CITY OF ALBUQUERQUE
PLANNING DEPARTMENT
DEVELOPMENT REVIEW BOARD

Project# 1010538
15DRB-70249 VACATION OF PUBLIC ALLEY
RIGHT-OF-WAY

DORIS RHODES/ THE COTTONWOODS LLC
request Vacation (Closing) for the Public Alley in
Block 29, **HUNING CASTLE ADDITION** located
south of LEAD AVE SW and west of 14th ST SW.
(K-13)

ADDITIONAL RIGHT-OF-WAY
 DEDICATED BY THIS PLAT
 (261.82 SF.)
 (SEE NOTE 7)

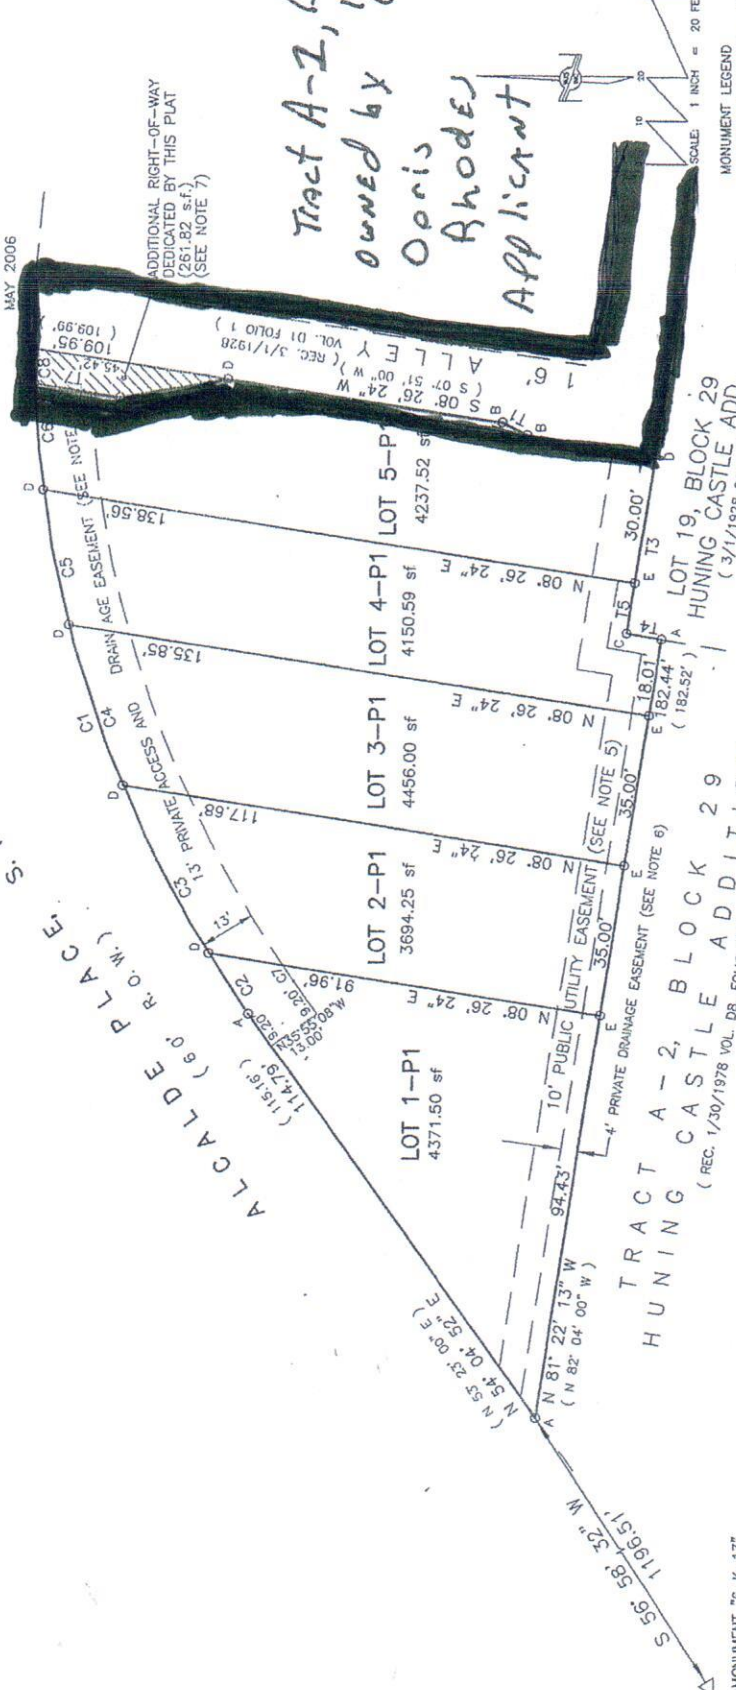
The City's Subdivision Ordinance allows that a request to vacate needs to be filed by "The owners of a majority of the front footage of land abutting the proposed vacation." The property owner on the west side of the alley and/ or the property owners on the south side of the alley that connects to 14th Street will have to be co-applicants in order to meet the requirements of the Subdivision Ordinance.

This is a continuous alley from Lead Avenue that connects to 14th Street. It is not consistent with the Subdivision Ordinance to have a dead-end alley, therefore the entire alley would need to be vacated and re-platted; Access Easements will be required where needed for adjacent properties. Refer to comments from Transportation Development/ affected agencies and any public hearing comments regarding the proposed vacation.

When I developed this project in 2006, 13' of the alley and also 261sf of the privately owned property, (which was dedicated as an Additional Right-of-Way) were set up as the only Ingress for this 5 home development (see attached plat).

If this is approved, all 5 homes would lose access to this development, which includes my 3 homes.
